Date: 05 December 2023
Our ref: 458247
Your ref: TR010032

**Application by National Highways for an Order Granting Development Consent for the Lower Thames Crossing
Natural England's response to Deadline 8
Natural England User Code: 20034784**

Code of Construction Practice – First iteration of Environmental Management Plan v7.0

*Local Landscape Character Area boundaries of the Kent Downs AONB LCA, West Kent Downs, Sub-areas Cobham and Shorne*

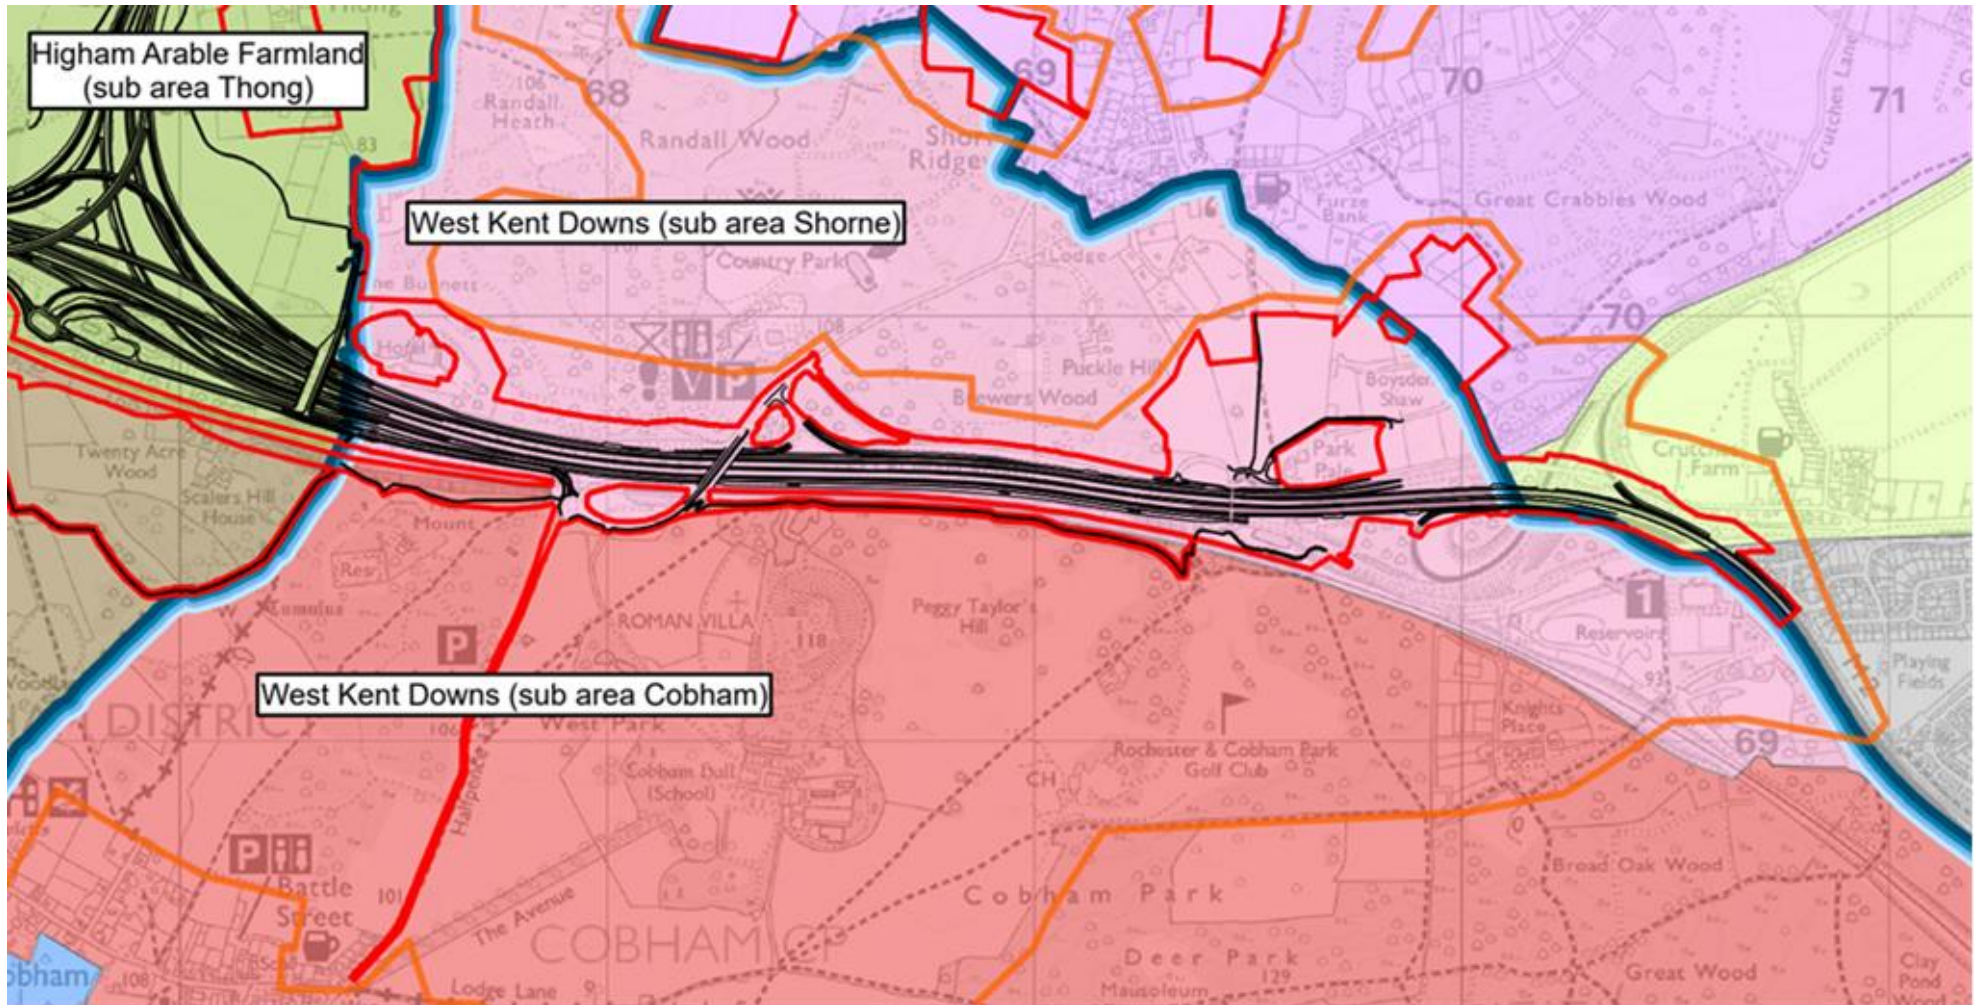
ii	<p>The Applicant has advised in response to both ExQ1 and ExQ2 why it has ‘adjusted’ the boundaries for the Cobham and Shorne Local Landscape Character Areas (LLCA) for the purpose of assessing landscape impacts; however, can it explain the level of sensitivity and significance of effects it would ascribe to those areas if the boundaries had not been ‘adjusted’ and instead the Kent Downs AONB LLCA boundaries (which echo the Kent County Council’s 2004 LCA) were used? Is there a difference?</p> <p>Having regard to the Applicant’s adjusted boundaries, can the Applicant explain what the significance of effect would be if the areas of Cobham and Shorne were not combined in the assessment but were considered and reported separately? Comments from the Kent Downs AONB Unit, Gravesham Borough Council and Kent County Council will be sought on the Applicant’s response.</p>
Summary of Natural	Natural England has no observations to make in relation to this matter beyond those within our Written Representation (Examination Document
